RESPONSE TO SUBMISSIONS REPORT

Hawkesbury Centre of Excellence - SSD 15001460

10 November 2021

Department of Education

Drawing Title
Proposed Roof Plan

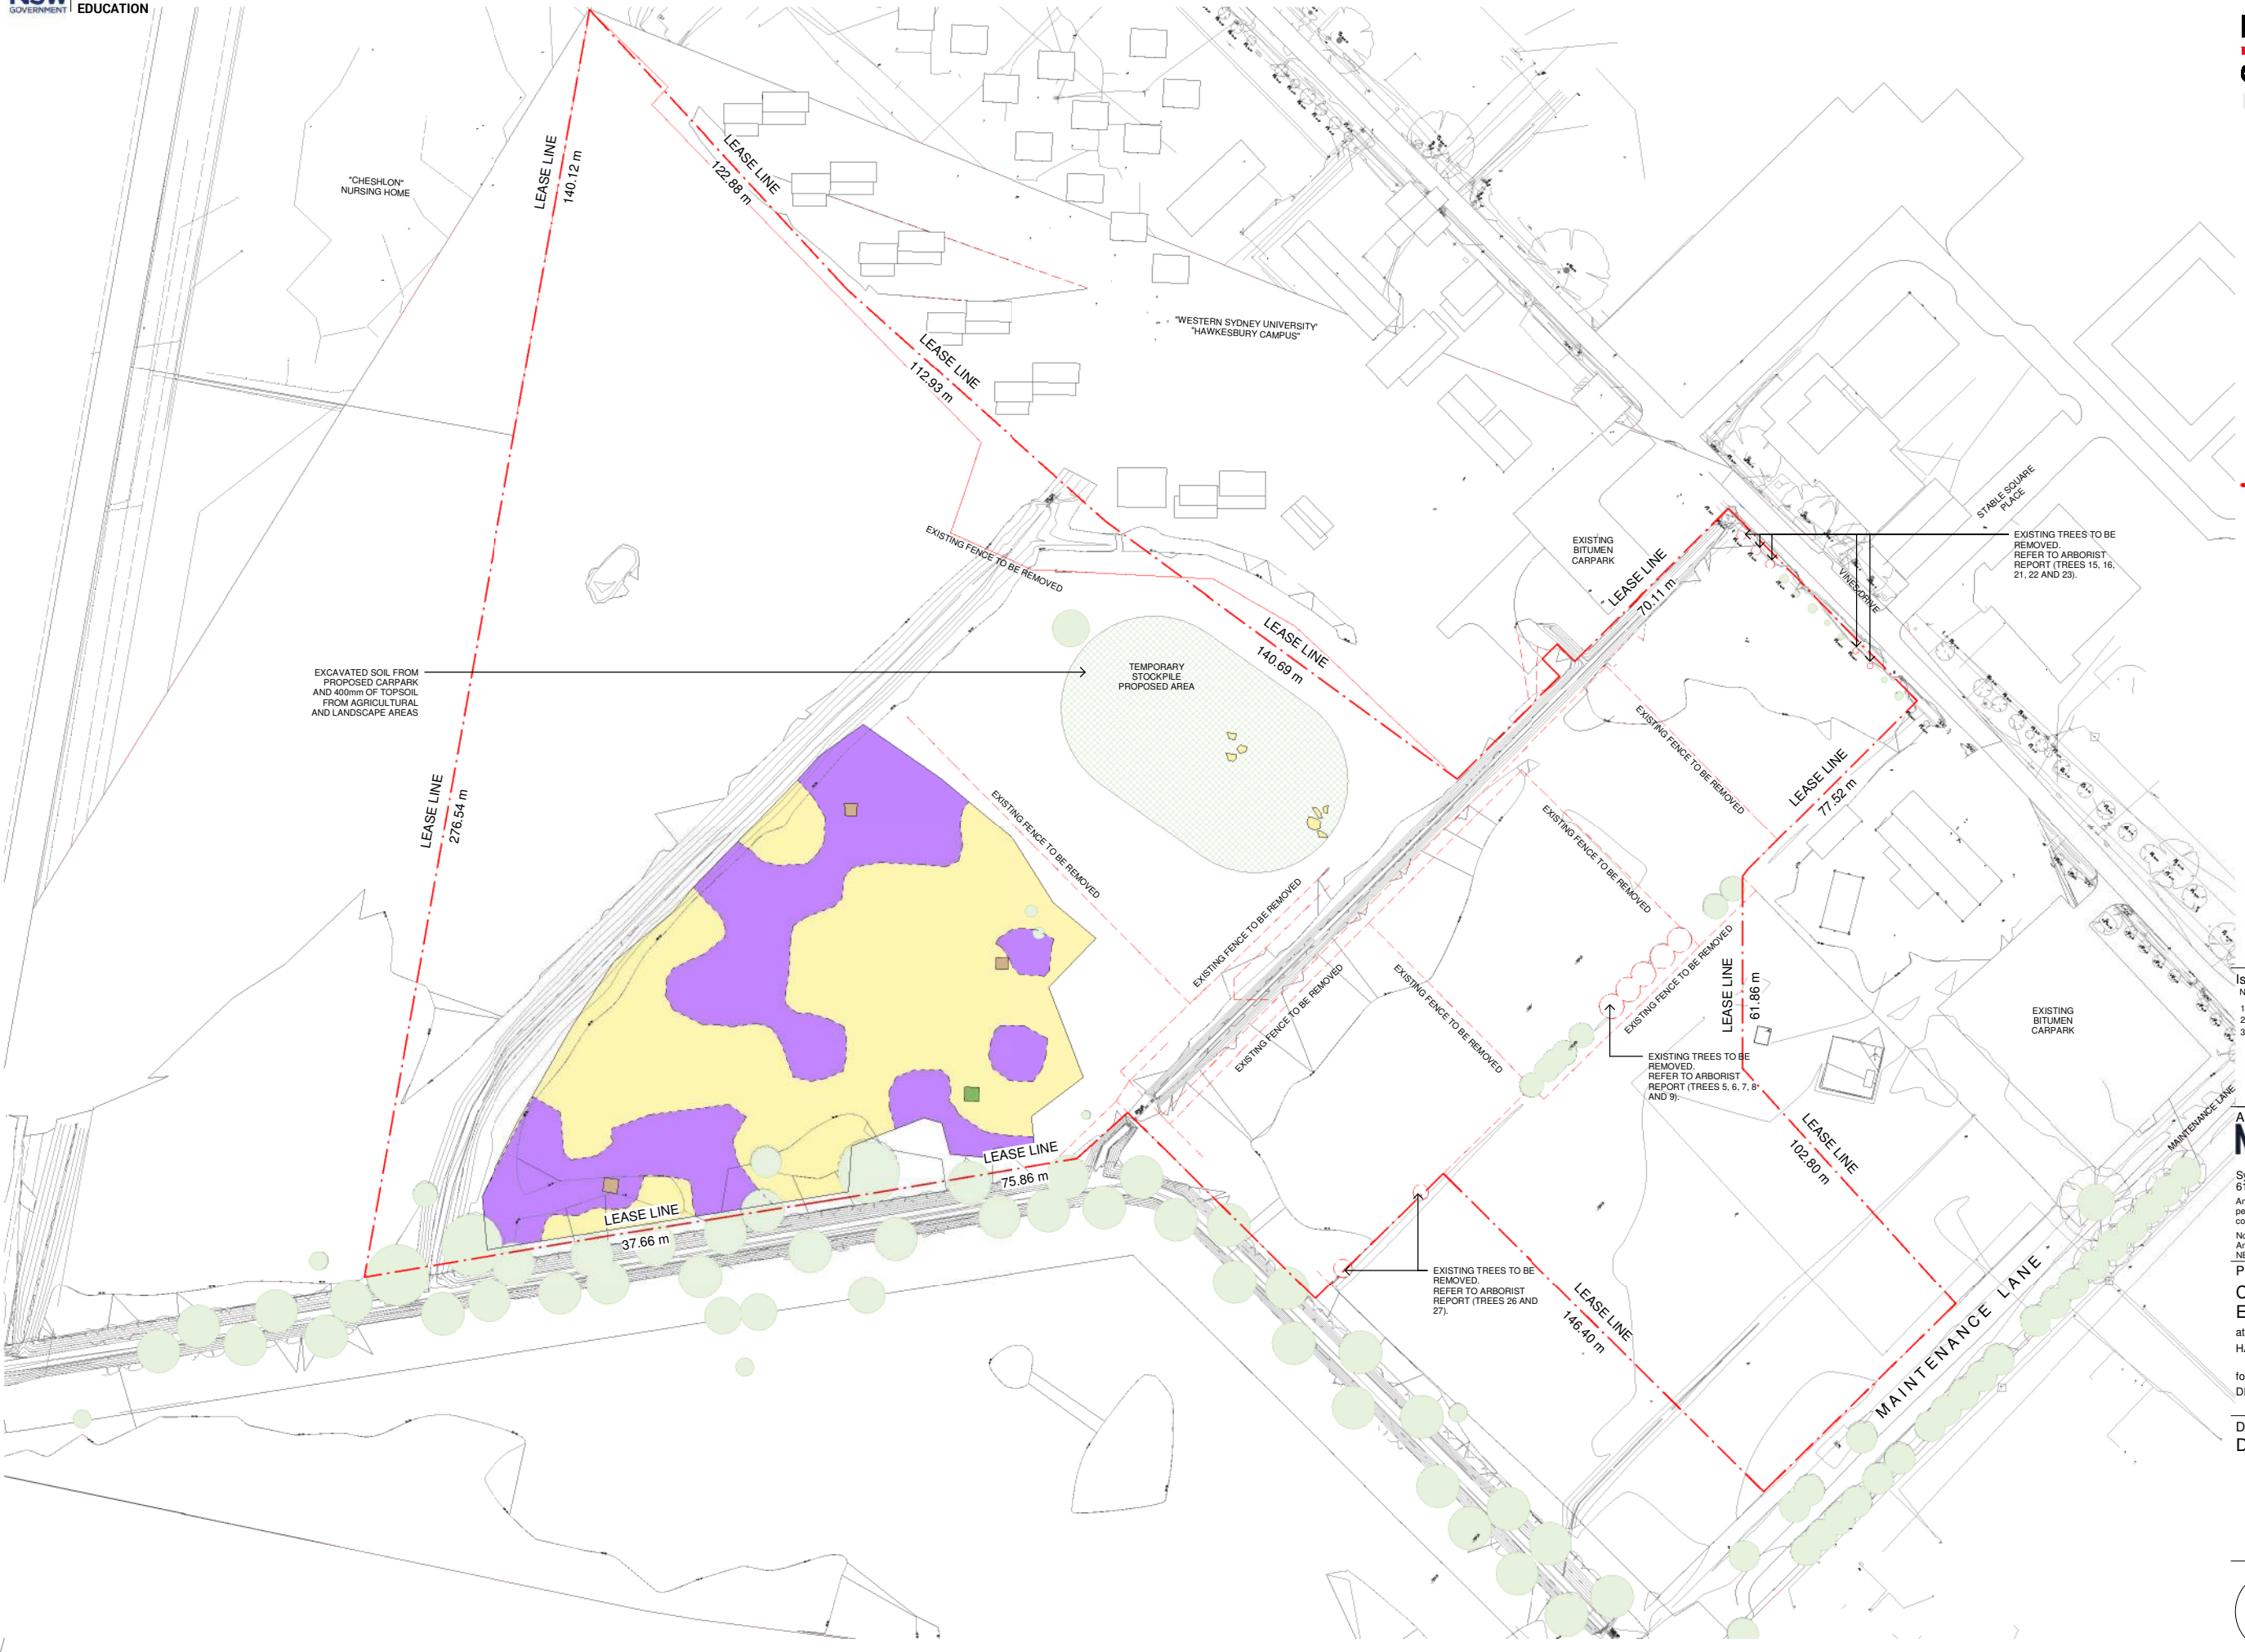
| Proposed Action / Change | Reason for Action / Change |
|---|--|
| Roof Form Adjustments | <p>This design rationalisation provides structural design efficiency for a more economical solution. The Main Entry Canopy located on the East of the Administration Block (Building A) has been shifted further south to provide covered Public Entry. The figure below highlights the extent of additions and reductions of roof area.</p> |

1 BLOCK C - NORTH ELEVATION 1
1 : 100

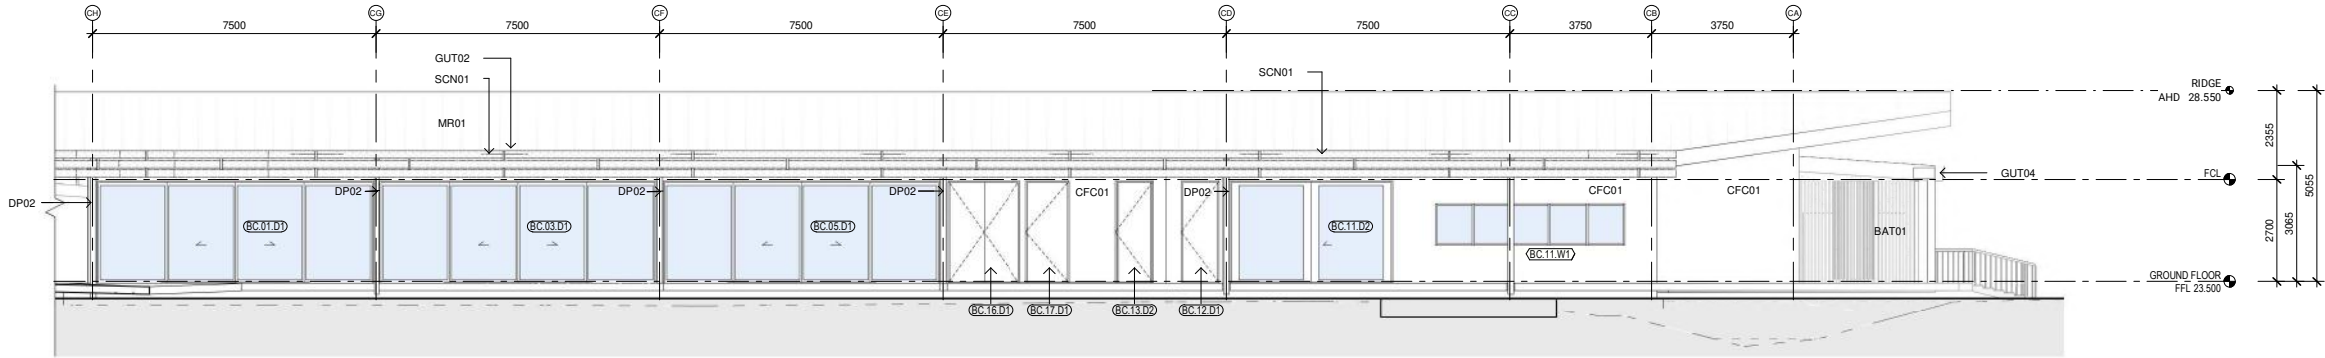
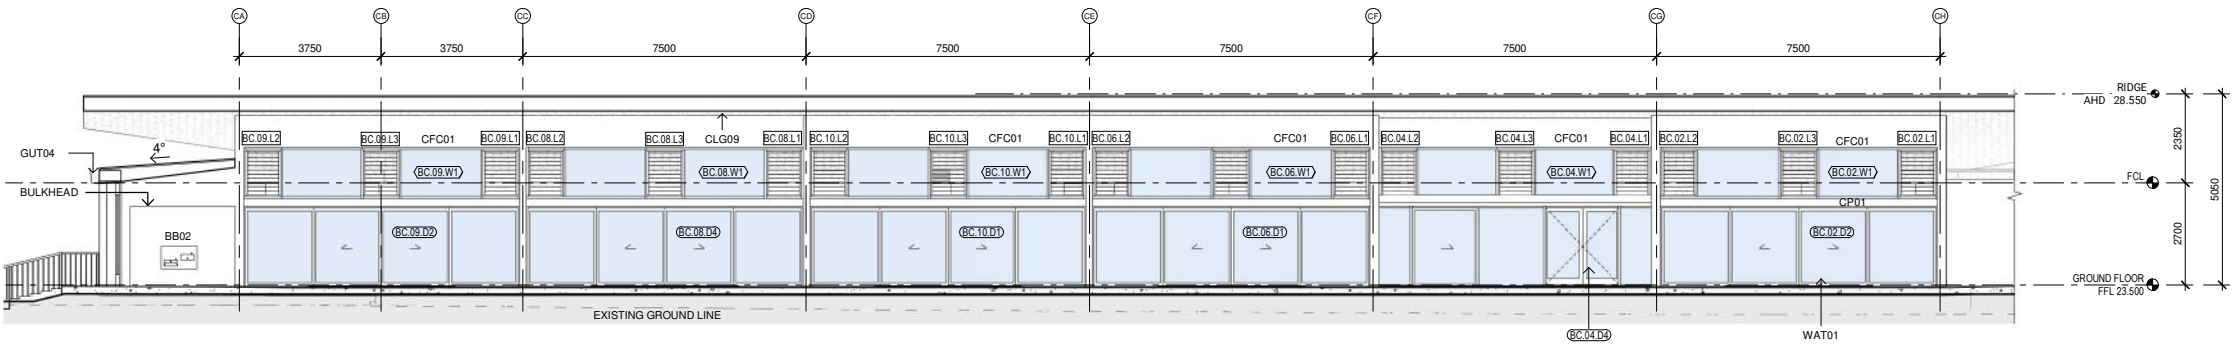
The three learning blocks, Building B, C and D, display a 15% reduction in glazing of walls.

This improves the overall structural design by providing additional structural support zones along the building facades. The highlighted areas in the elevation figures below illustrate the proportion of glazed façade that has been replaced with metal cladding with batt insulation. It should be noted that the glazed area remains over and above the BCA requirement for daylight harvesting.
